From: Contact Centre (CRM) <contact@ribblevalley.gov.uk>
Sent: 28 August 2026 05:43
To: Planning
Subject: Planning Application Comments - 3/2026/0603 FS-Case-869107373

Planning Application Reference No.: 3/2026/0603

Address of Development: Land adjacent to Fernhill Ribchester Road Clayton Le Dale BB1 9EG

Proposal: Outline application for the proposed erection of two dwelling houses with access applied for.

PROPOSED SITE PLAN
(illustrative only)

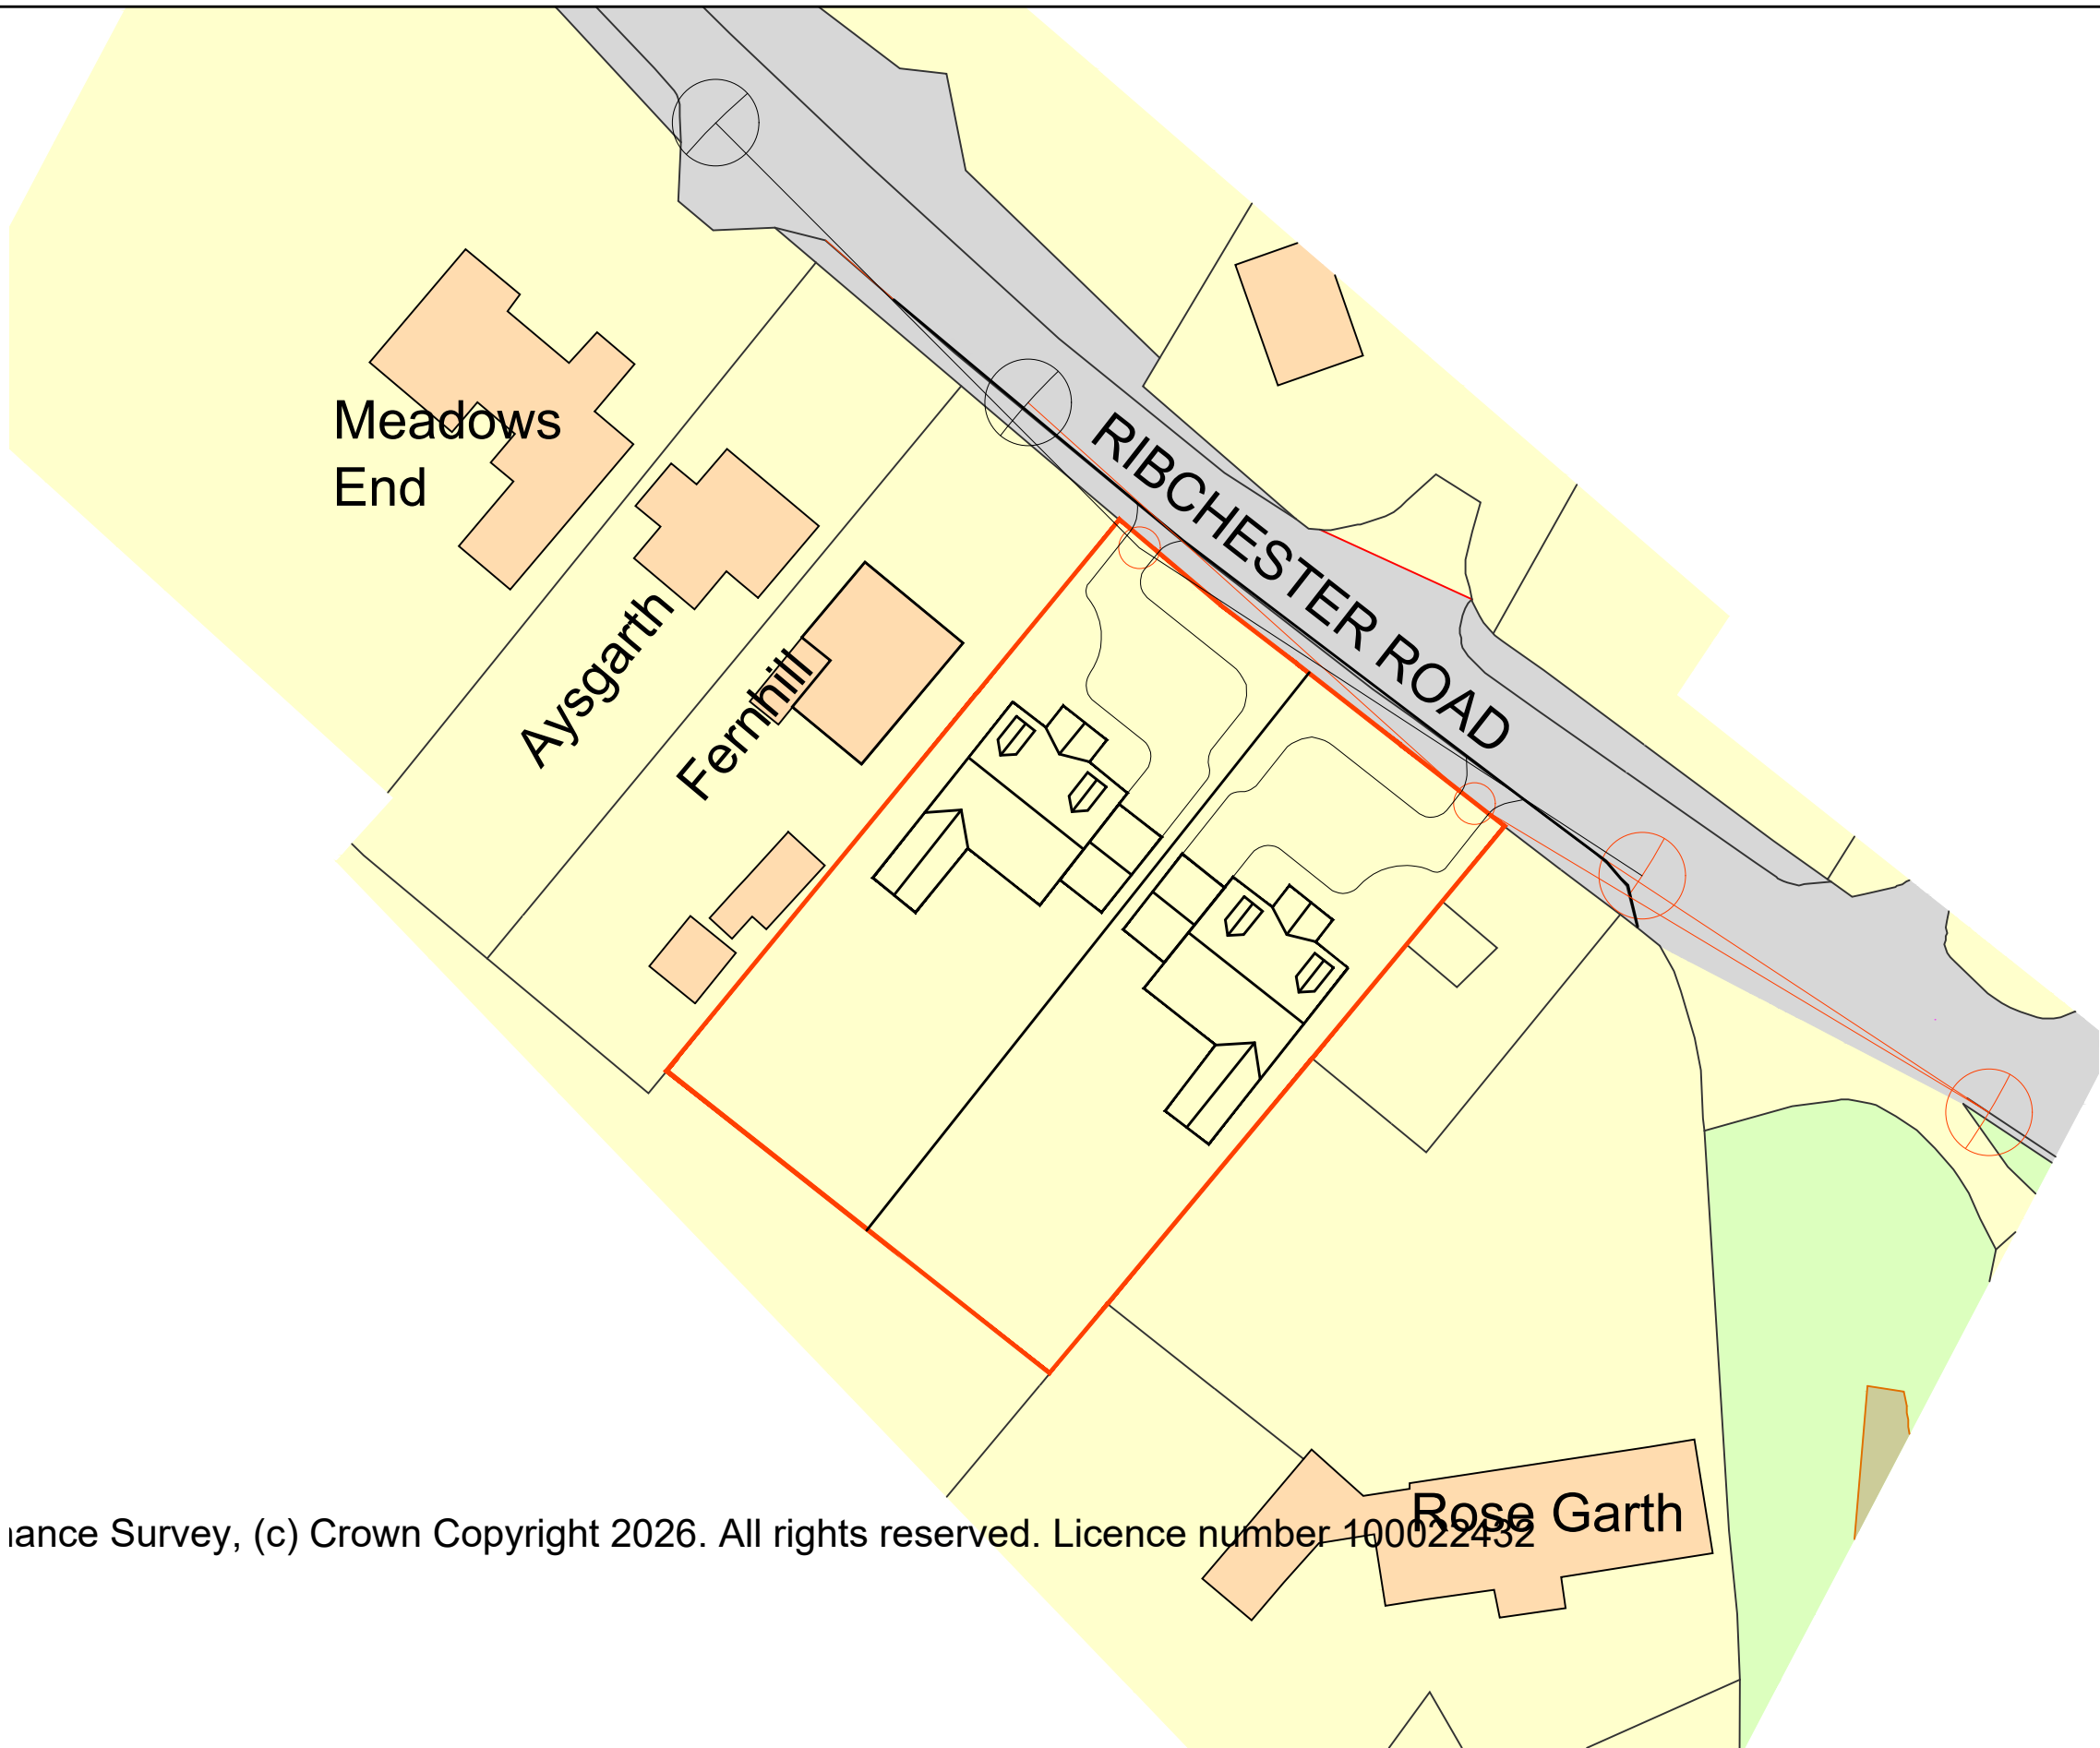
The entrance to Oaks Quarry Garage is less than 50m from the proposed development. Many large articulated lorries enter and exit Oaks Quarry Garage at all times of the day. Visibility for lorries exiting Oaks Quarry Garage is poor and visibility of cars leaving the proposed development is limited by a large stone wall and a large hawthorn tree belonging to 197 Ribchester Road.

This increases the chances of a road traffic accident for cars entering and exiting the proposed development.
